Objection to planning application reference 6/2021/0773/FULL.

CLIENT:	PRIVATE CLIENT
JOB:	1 - 22 Maynard Place Cuffley EN6 4JA
DRAWING TITLE:	Existing Second Floor & Roof Plan
SCALE:	1:200 @A3
DATE:	March 2021
STATUS:	Planning Application
DRAWING NUMBER:	1254.01.PA2.011
REV:	
ISSUED BY:	CF

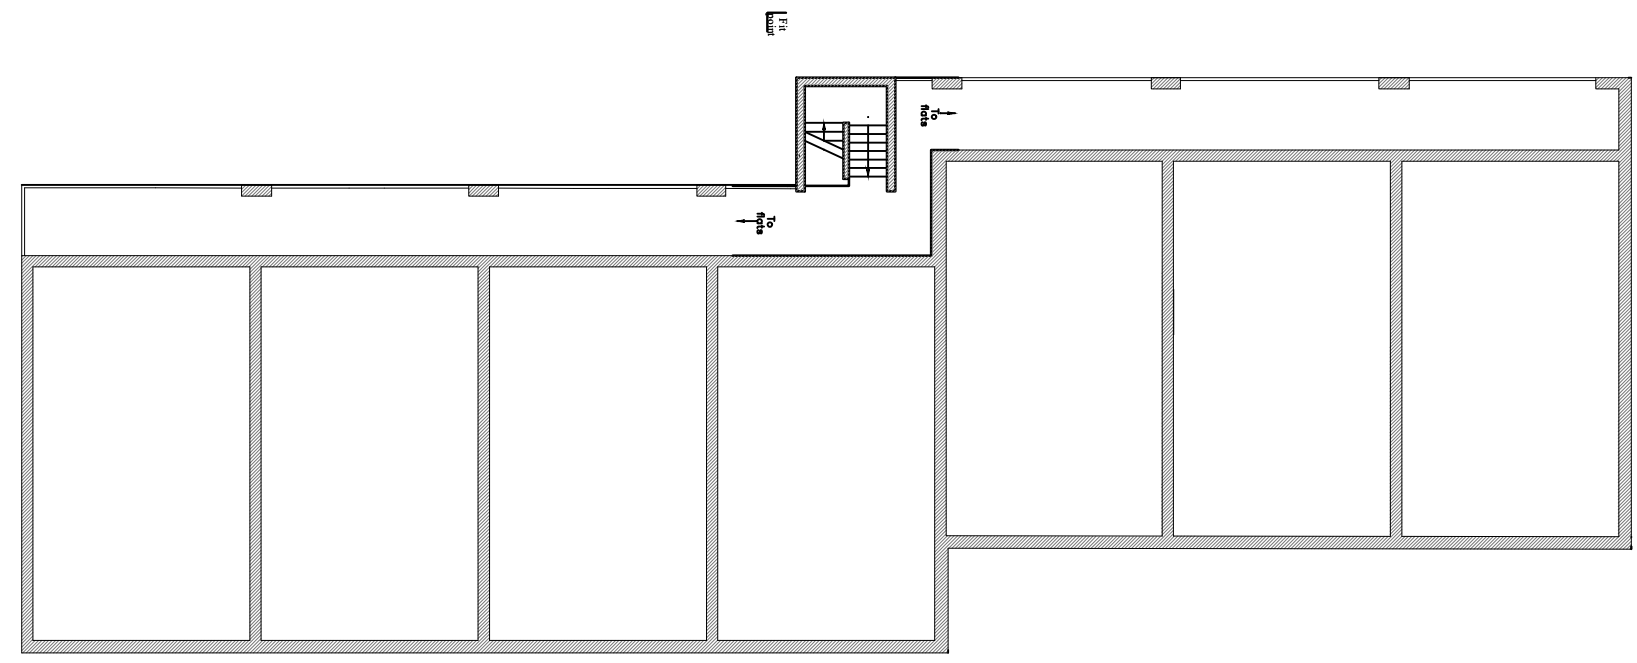
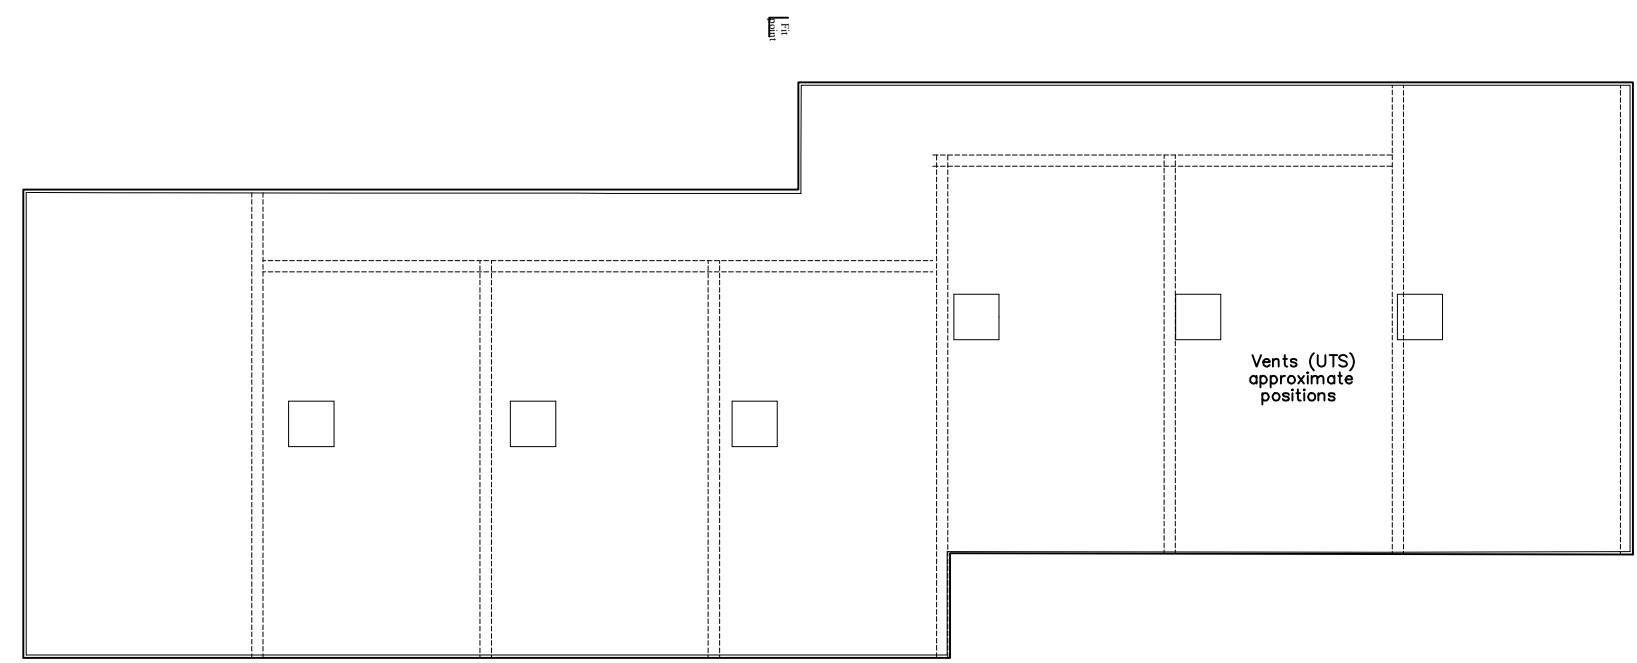
D. Skylights in the roofs of the existing second floor flats.

I understand all the existing second floor flats have sky lights that let natural light into them. Obviously they would lose this if new flats are built on top and I know a number of them object to the new flats because of this.

DRAWING TITLE:
Proposed Ground Floor Plan

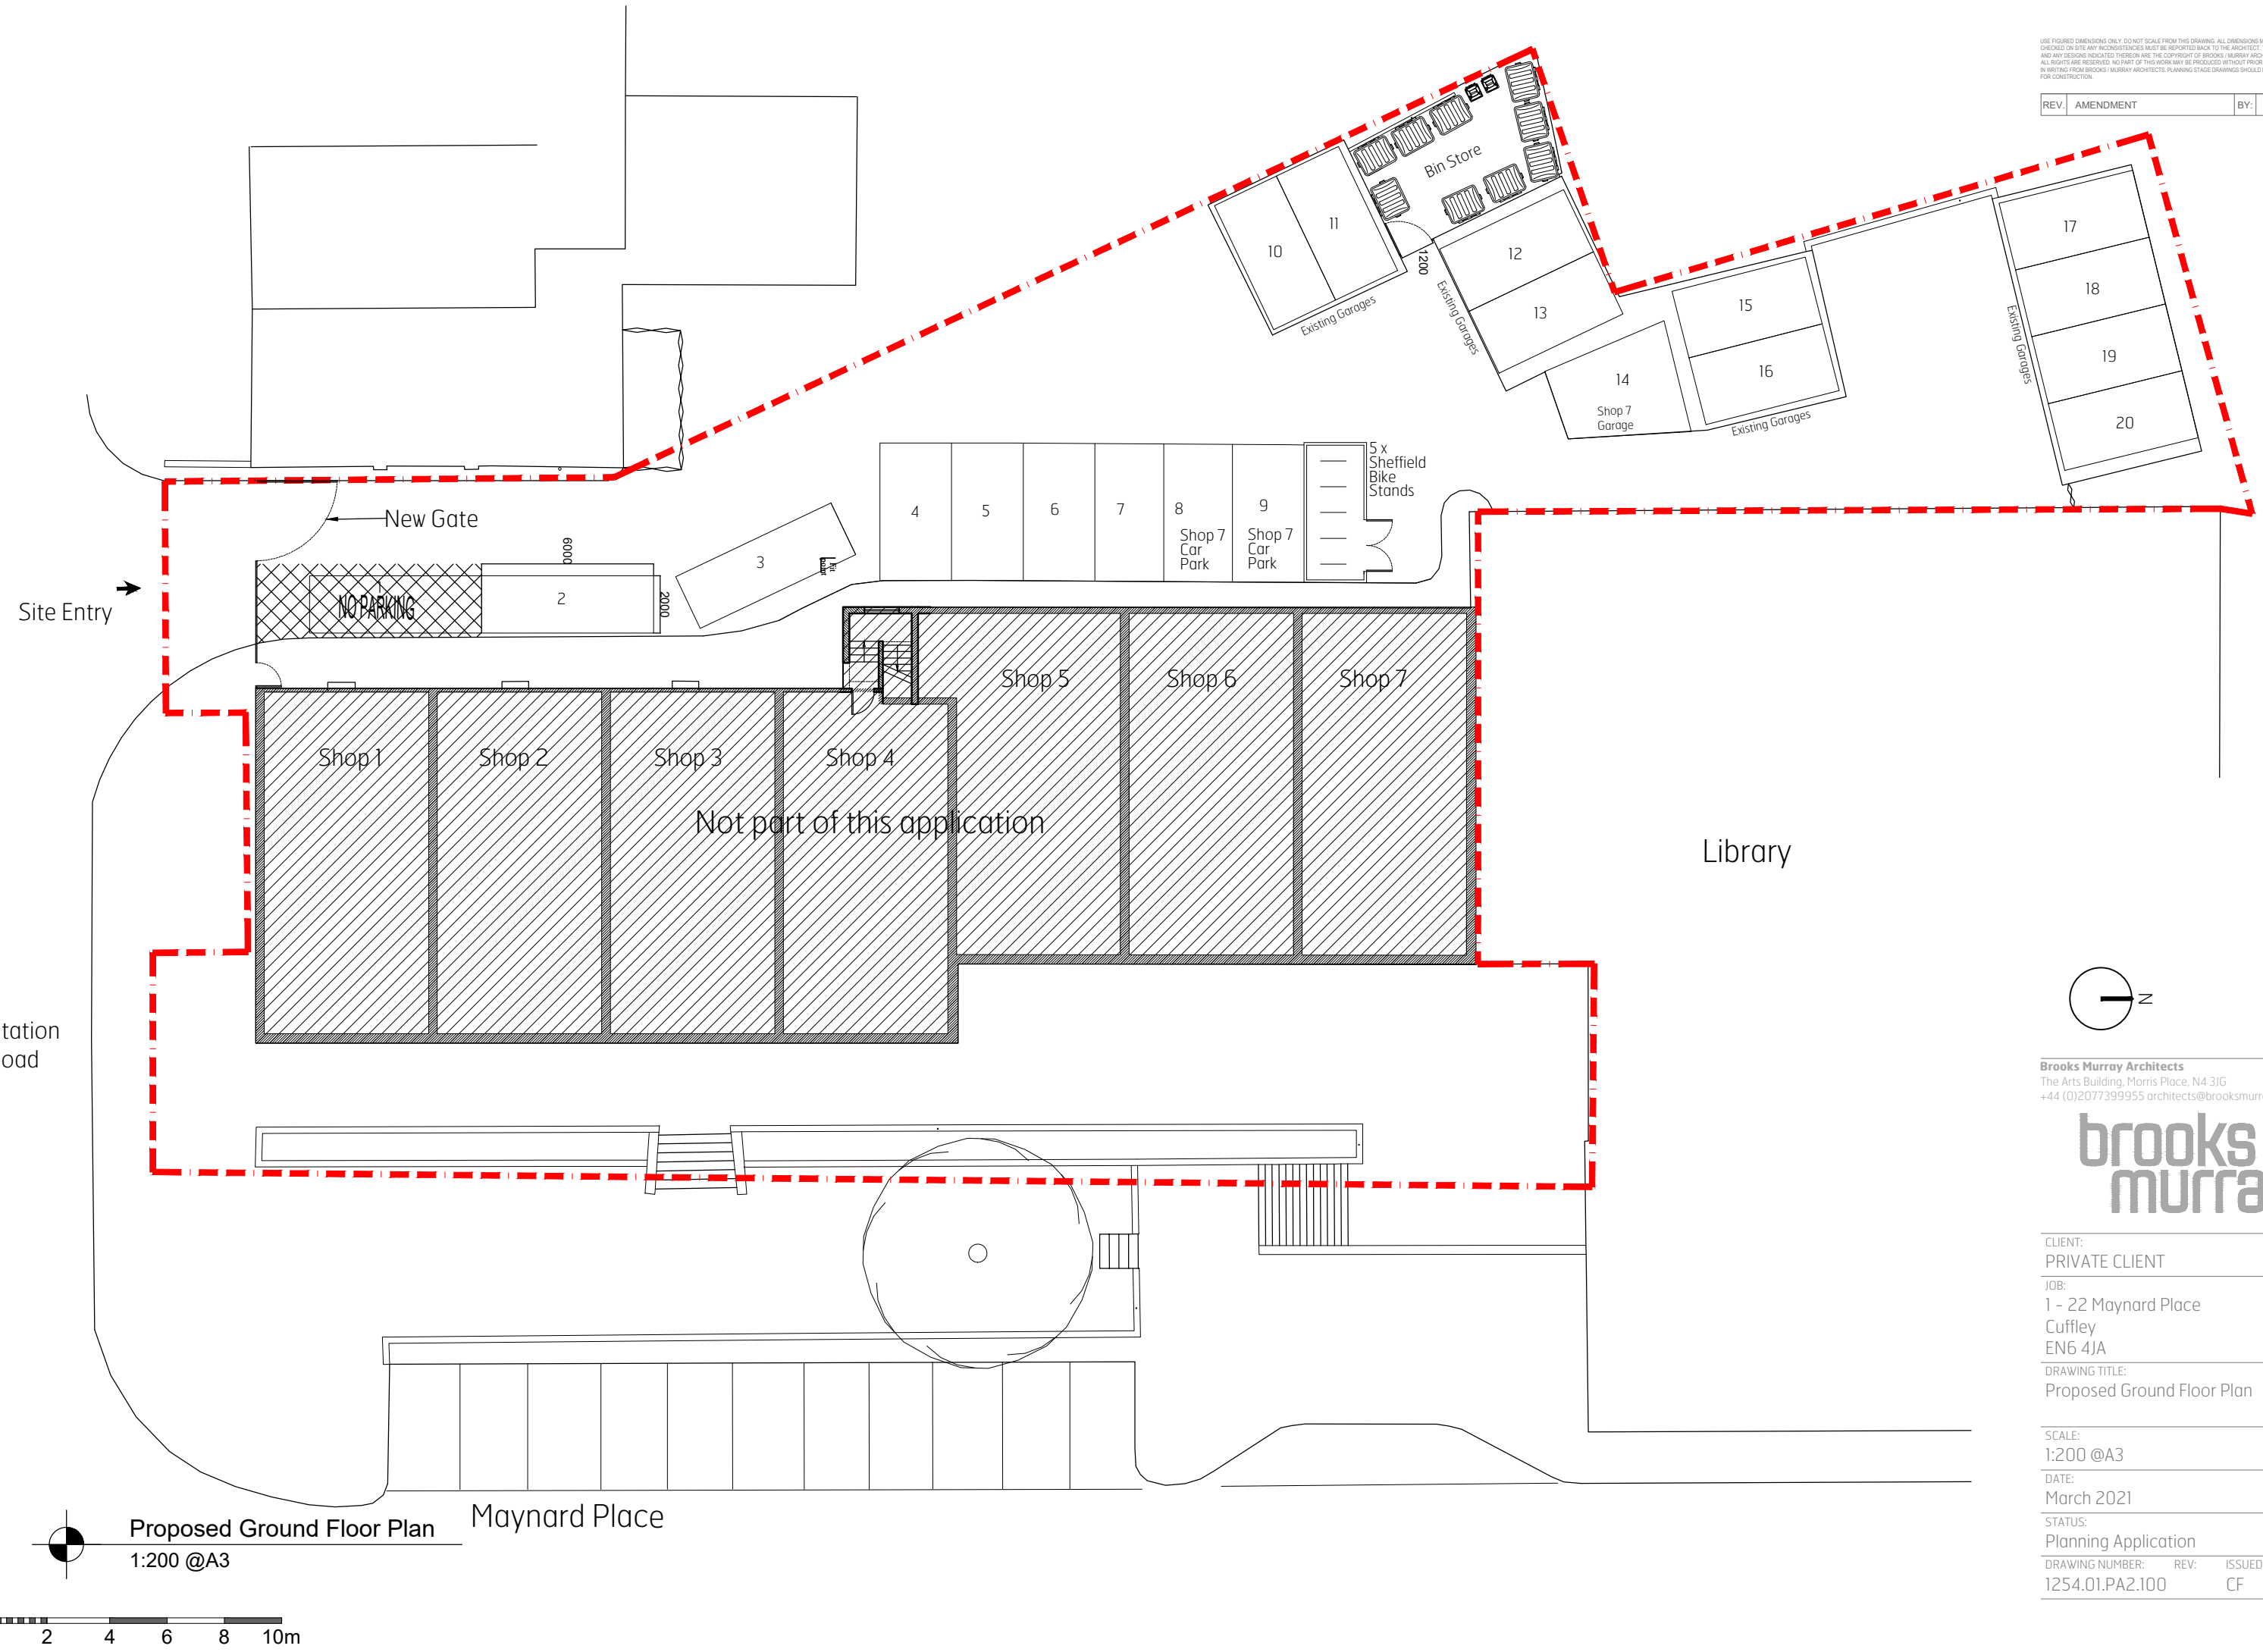
This item is incorrect. Item 2.2 says “The car park includes a total of 11 unallocated parking spaces along with 11 additional garages allocated to existing flats. Overall, the site includes a total of 22 on-site parking spaces.”. The truth is the following:-

1. **The 11 existing garages are NOT used for parking.** They are too small and as the applicant for planning is aware are rarely if ever used for parking. The garages are **only 2300mm wide**. Even a standard VW Golf cannot be parked in one of these garages as **you cannot open the door to get out of the car!** The garages are used for storage and many of them are rented out to the shop owners. Therefore there are NOT 22 on-site parking spaces available, but only 11 including the two owned by the parish council. So only 9 spare spaces for 14 EXISTING flats and 6 shops (excluding the council office “shop”).
2. **The garages are NOT “allocated to the flats”.** Many of the garages have been SOLD to others and so are nothing to do with the flats. They are rented out mostly to the shop owners for storage.

In summary there are 9 plus 2 (council) parking spaces in total at Maynard Place, making 11 spaces. The garages are NOT spaces as they are not usable due to their small size. The document says 1.25 spaces are needed for a one bedroom flat and 1.5 spaces for a two bedroom flat. What is needed is as follows:-

- a) For the existing 14 flats by the guidance (two bedroom flats need 1.5 spaces) so we need $14 \times 1.5 = 21$ **for the existing flats. Not even enough spaces now!** The residents, shop owners and the landlord are fully aware there are major parking problems at Maynard Place already. Any more vehicles would mean total chaos with people having to pay to park their own cars.
- b) For the new flats the document states “The proposed new flats would provide 3 x 2 bed units and 3 x 1 bed” resulting in a car parking need of 9 (3×1.5 plus $3 \times 1.25 = 9$).

The total parking spaces requirement for the existing plus new flats is therefore **30 spaces** (21+9). **We only have 11 so we would be short of 19 car spaces. Even without new flats we are already short of 10 spaces by the guidance notes!**

Proposed Third Floor Plan
1:200 @ A3

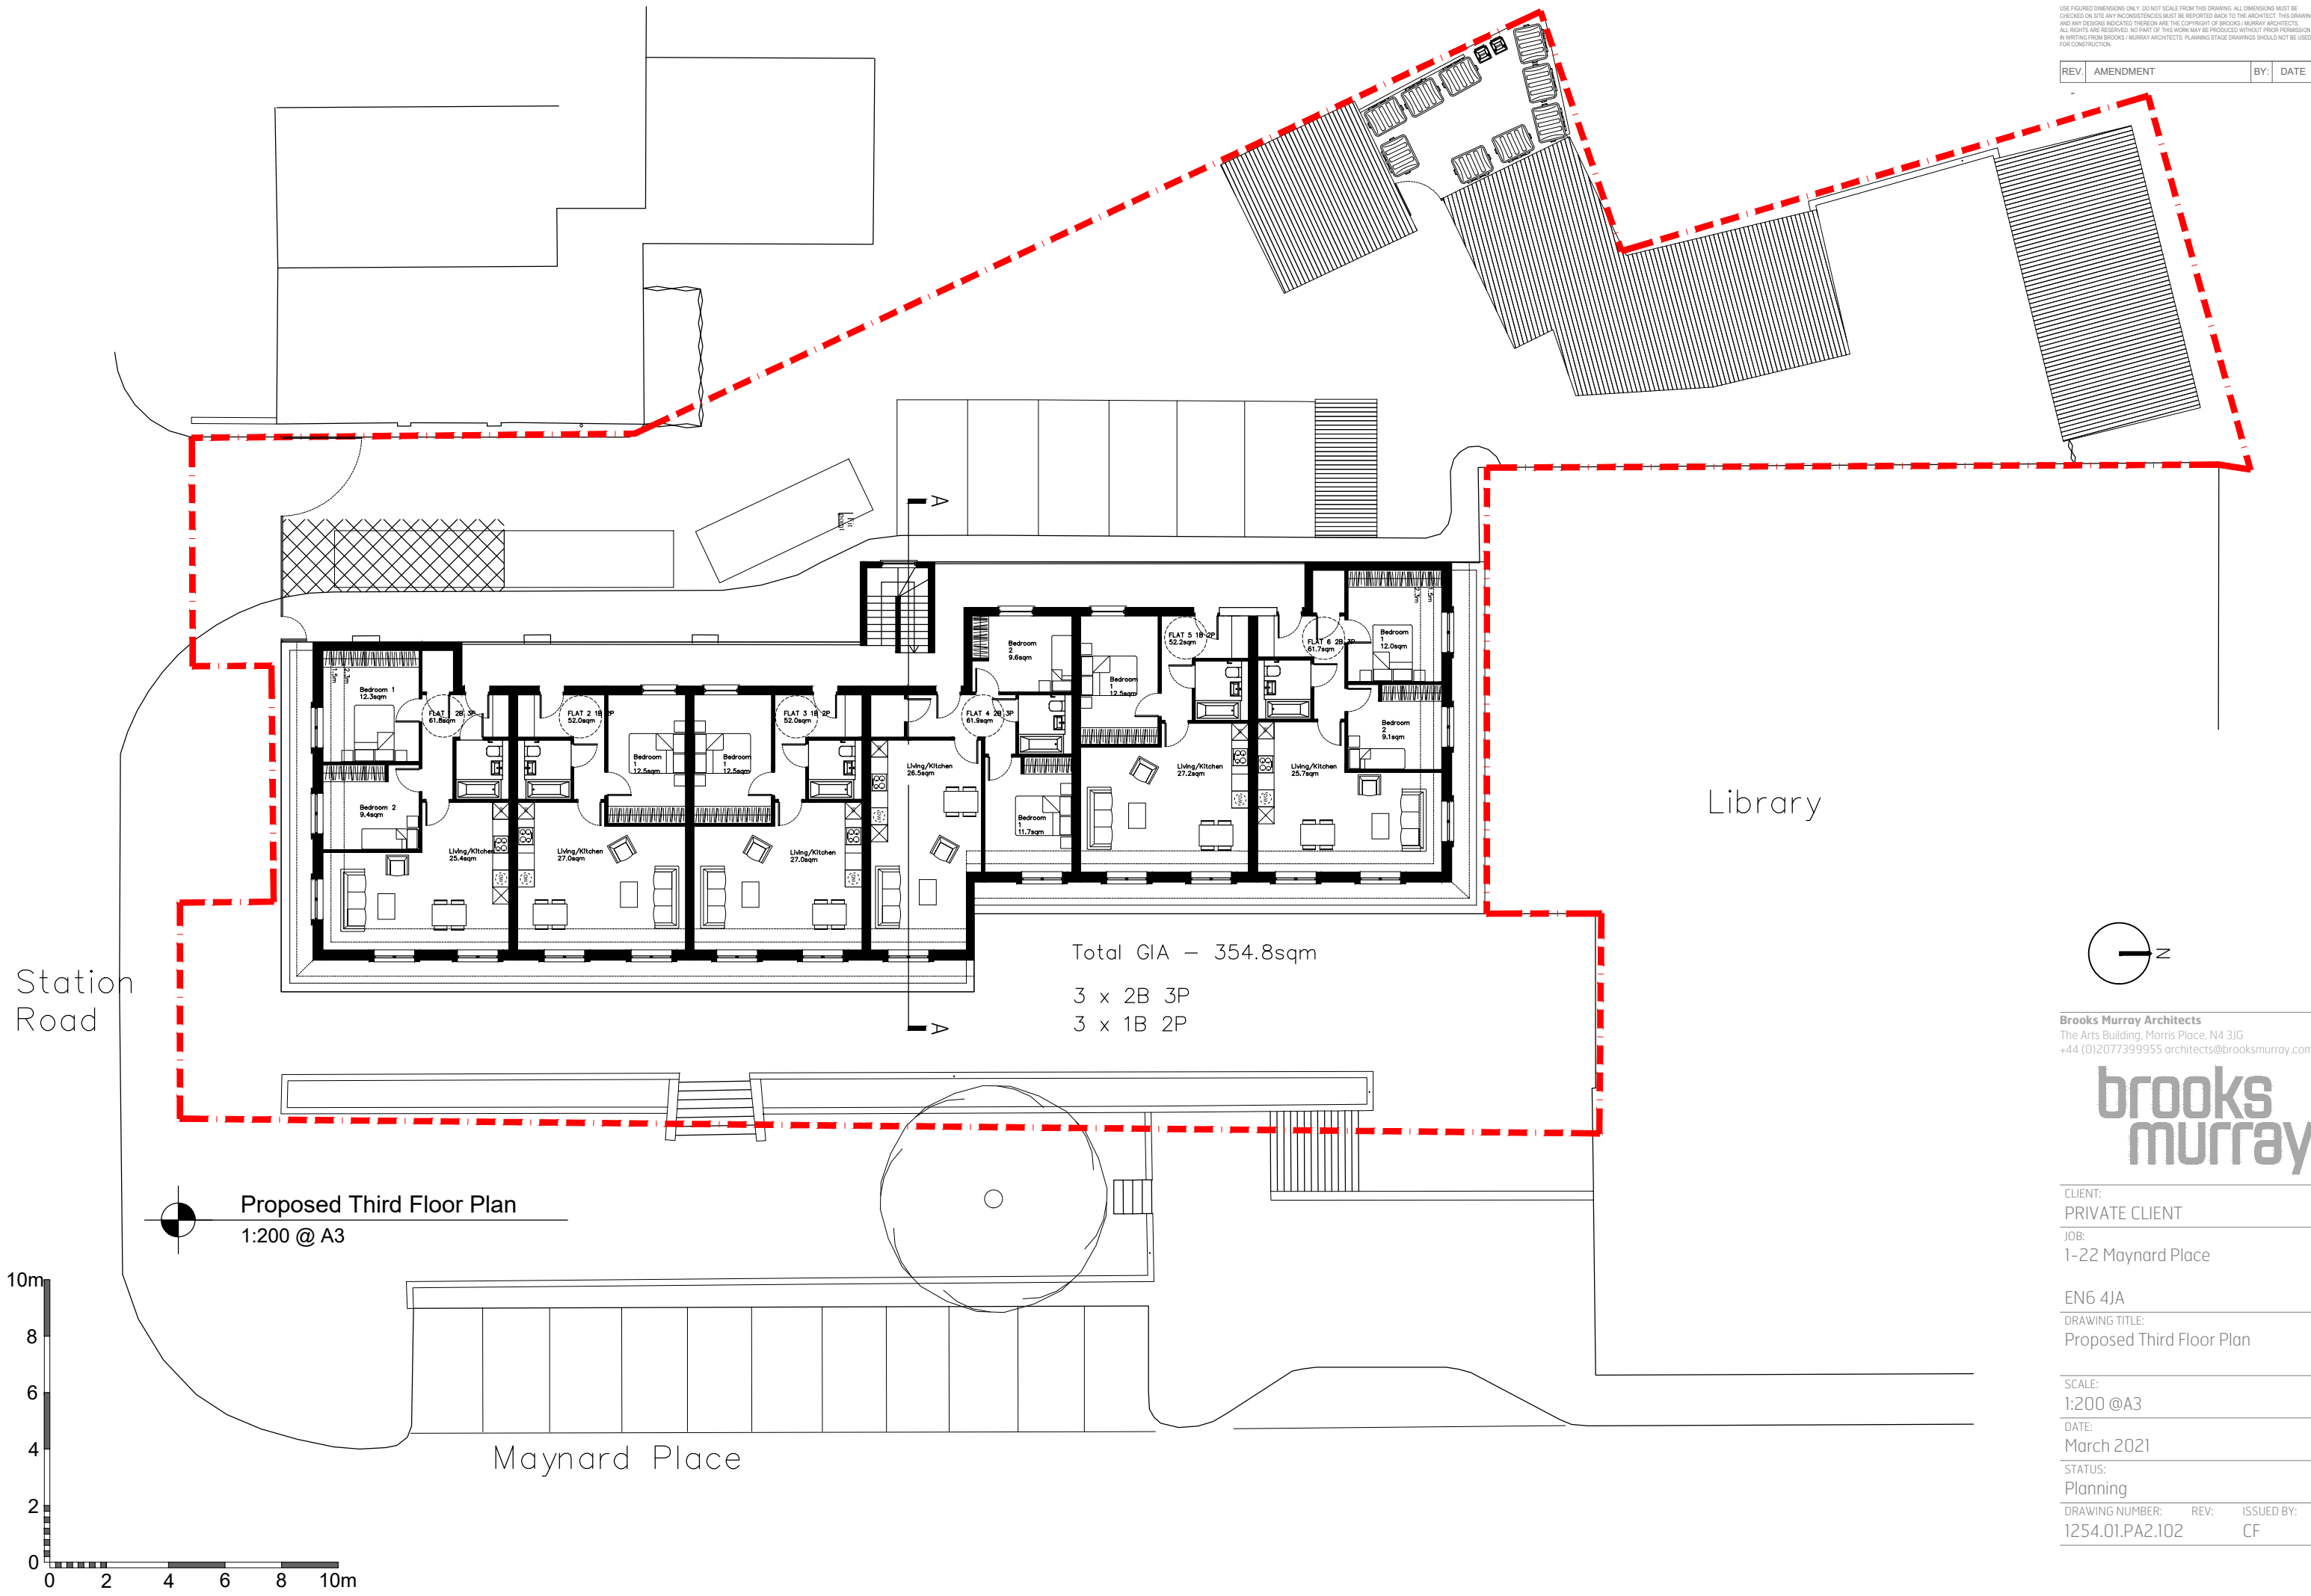
C. All buildings in Cuffley High Street are no more than 3 storeys high (Grd, 1st and 2nd).

If this extension goes ahead then Maynard Place will be the **only building on the high street 4 stories high**. Also it would set a precedent and Cuffley would become a giant building site for years to come. I think the entire population of Cuffley would be generally horrified if this 3rd floor extension gets planning permission.
